Andrew Beattie - Relocation of Berry Equestrian Centre

The Issues Associated with the Design of the Proposed Relocation of the Berry Equestrian

This submission concerns the impact of the proposed Foxground and Berry Bypass on the Berry E in North Street Berry.

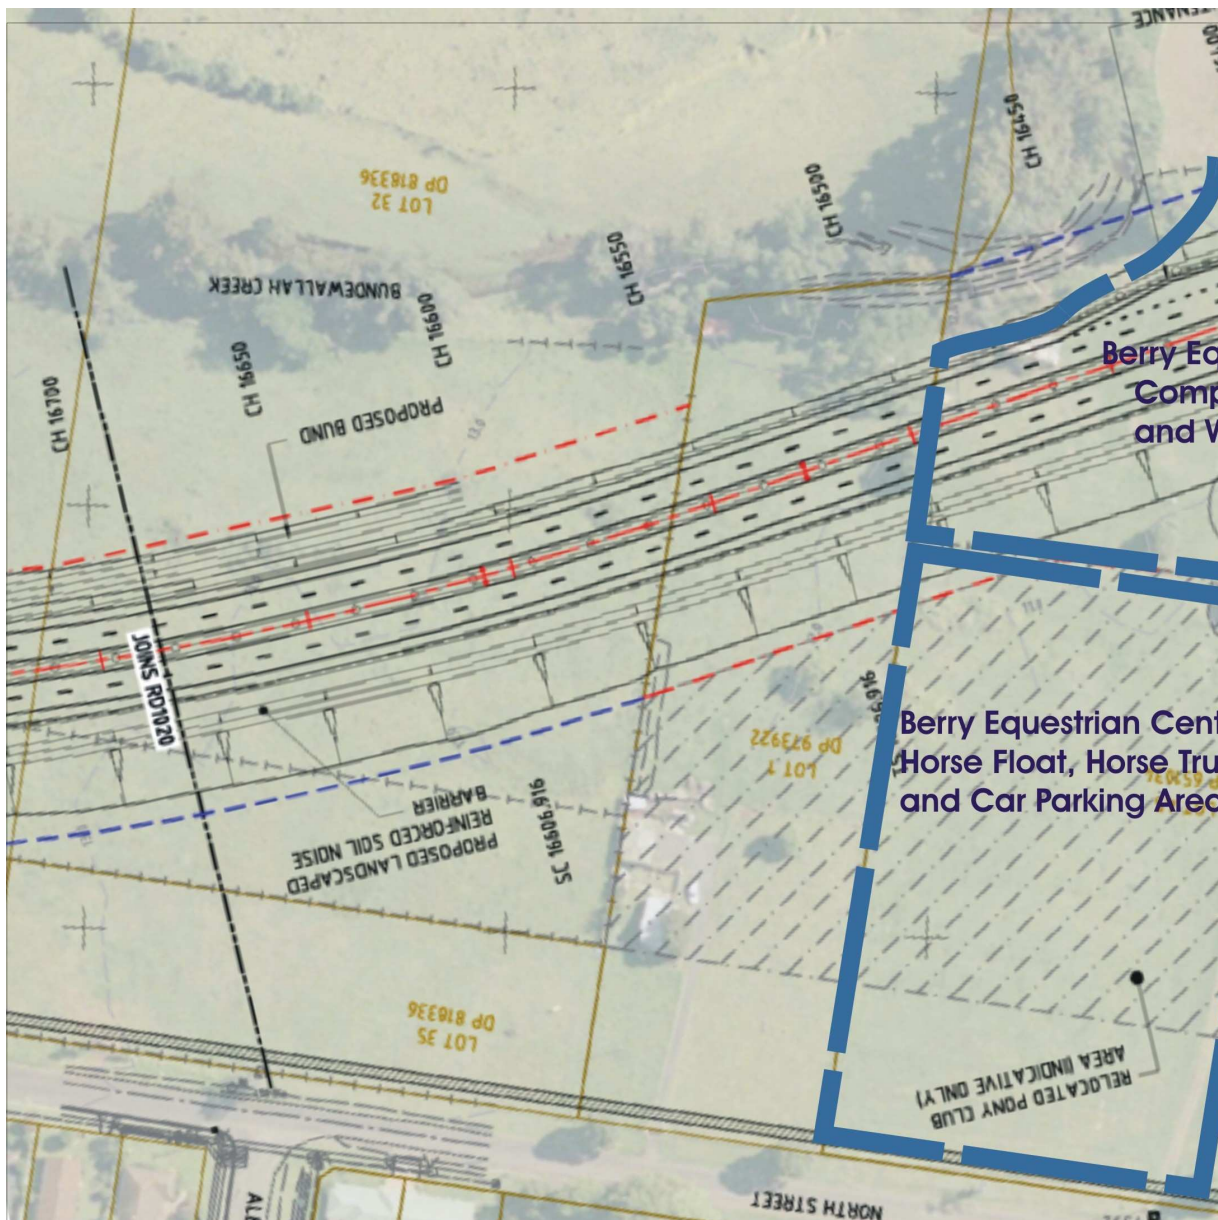
1. The competition grounds are required to be rectangular /square in shape of a minimum size level, well drained, good riding surface in order to cater for at least 4 dressage arenas or 2 s

2. The parking area is required to be of a minimum area equivalent to 90 metres x 160 metres maneuverability, parking and exit of horse floats and trucks. Each parking space is equivalent normal vehicle spaces due to the need for unloading/loading and tie up areas for horses.

3. There is concern for the safety of horses, riders and the general public due to the near locati the 4 lane expressway, the skateway, the public cycleway/walkway and North Street. There increased noise and visibility of cars and trucks travelling at 100km/hour on the expressway often with young, very inexperienced riders.

4. Access to the grounds is likely to be across a public shared cycleway/pathway. The safety o bicycles etc are at risk as horse trucks and floats cross the pathway. Horse floats and trucks driveway of at least 15 metres to allow vehicles to park off the roadway whilst gates to the g
